To: Dimitri Gotsis
Subject: Response to RFI - SIDRA Modelling

From: Dora Choi <dora.choi@asongroup.com.au>
Sent: Tuesday, 25 January 2022 4:43 PM
To: Tarini Pathak <Tarini.Pathak@turntown.com>
Cc: Stephanie Leaper <Stephanie.Leaper@turntown.com>; Wendy Zheng <wendy.zheng@asongroup.com.au>
Subject: RE: Upgrade to North Sydney Public School SSD-11869481 - Request for Additional Information

Figure 14: Existing intersection layout as modelled in SIDRA Intersection 9

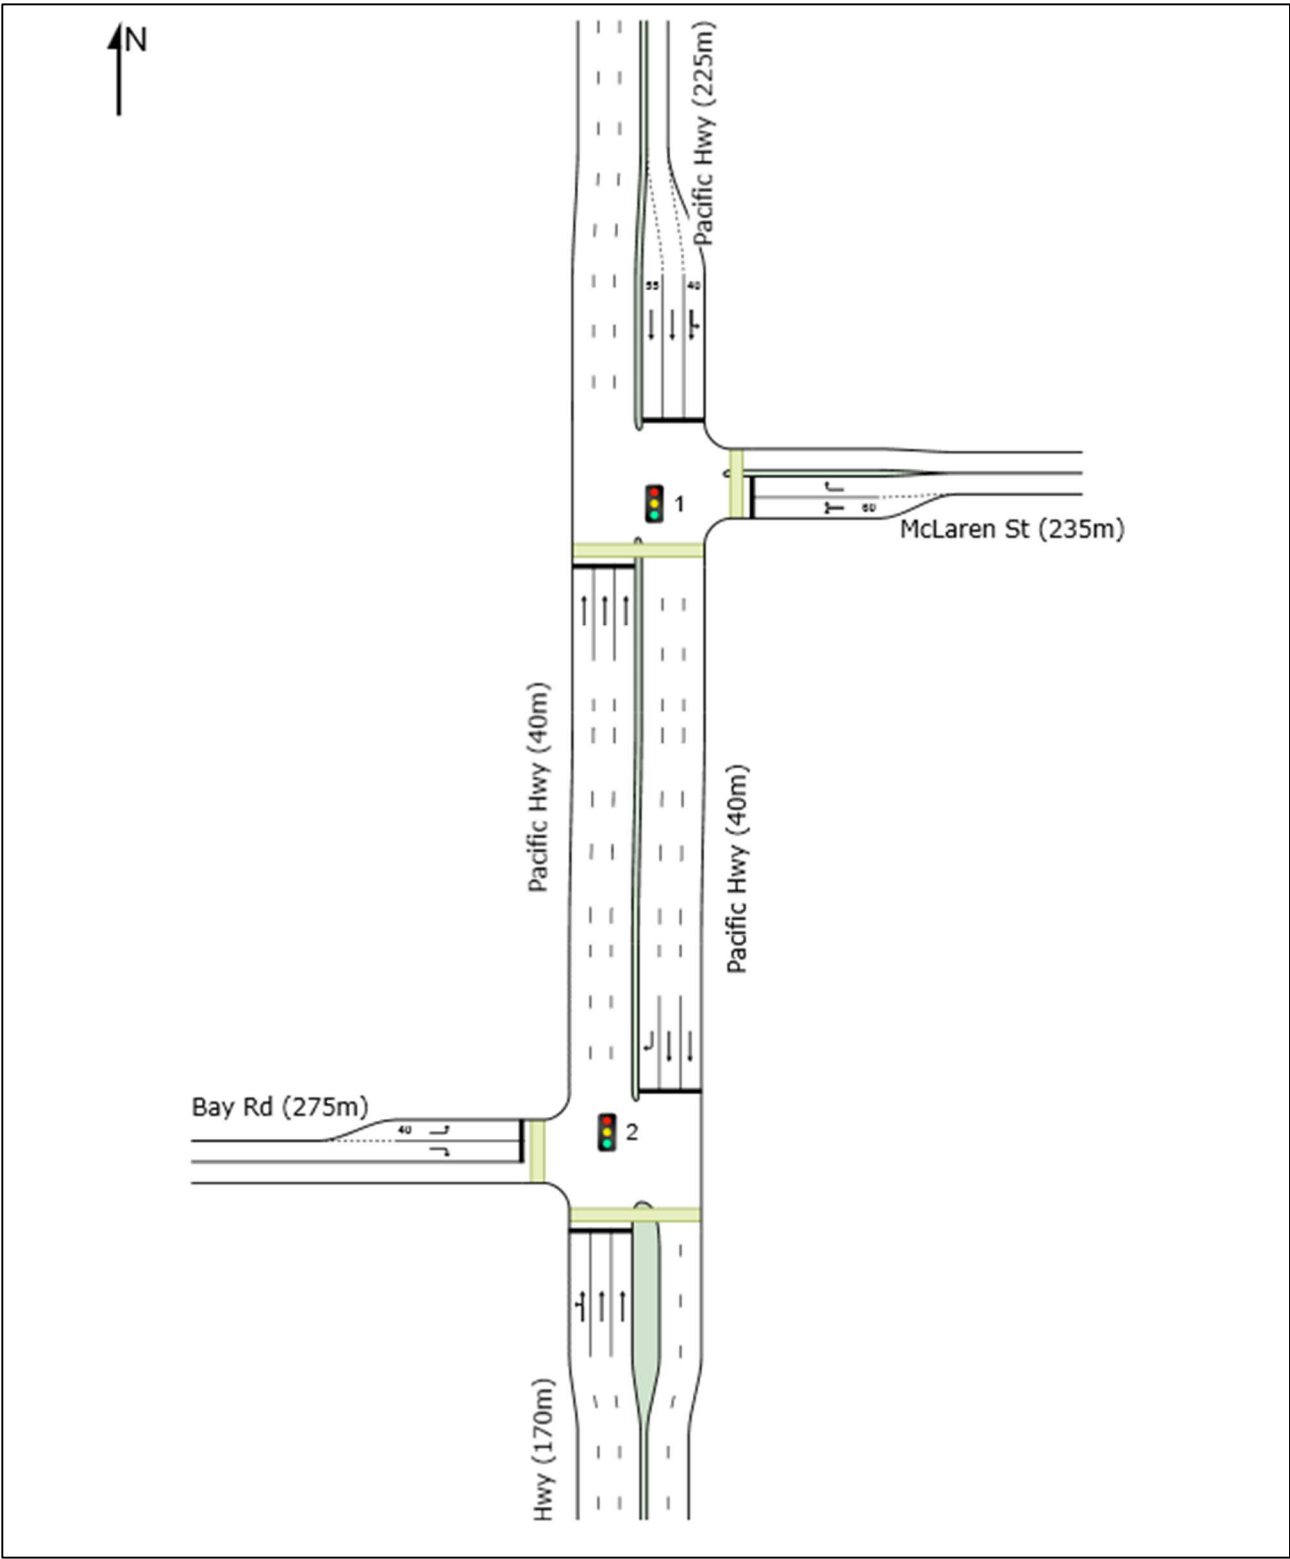
Upon receipt of the RFI, we have reviewed the comments and fundamentally, the question raised by DPIE relates to the application of optimised phase and cycle times in SIDRA modelling outlined in Page 55 of the Transport Assessment based on assumed improvements to phase and cycle times.

The 2033 analysis presented originally was optimised in both the phase time and cycle time.

The reason why 2033 analysis was prepared based on optimised phase time and cycle time due to SIDRA crashing – as a result of the DoS and LoS using existing phase time causing a failure in the model in the PM 2033 using existing Phase Time. Refer to the attached error message. The reason for the error is because the DoS and LoS exceeding the maximum link capacity by a factor that is beyond the settings of SIDRA.

It is further noted that the phase time is adaptive to traffic conditions throughout a typical day whereby SCATS automatically adjust phase time to suit demand and therefore is not completely fixed and can adjust within the fixed Cycle Time set, in this instance, 120 seconds in both existing and future scenarios.

For clarity, we have prepared the following comparison table, whereby the summary with red border was previously reported.

In the revised table below, we have now included the following additional Scenarios for 2033:

- Scenario 4A – 2033 base case on existing Phase Time (PT), and Cycle Time (CT) of 120s

- Scenario 5A – 2033 base case + Development Traffic on existing Phase Time (PT), and Cycle Time (CT) of 120s
- Scenario 4B – 2033 base case on optimised Phase Time, and Cycle Time of 120s
- Scenario 5B – 2033 base case + Development Traffic on optimised Phase Time and Cycle Time of 120s
-
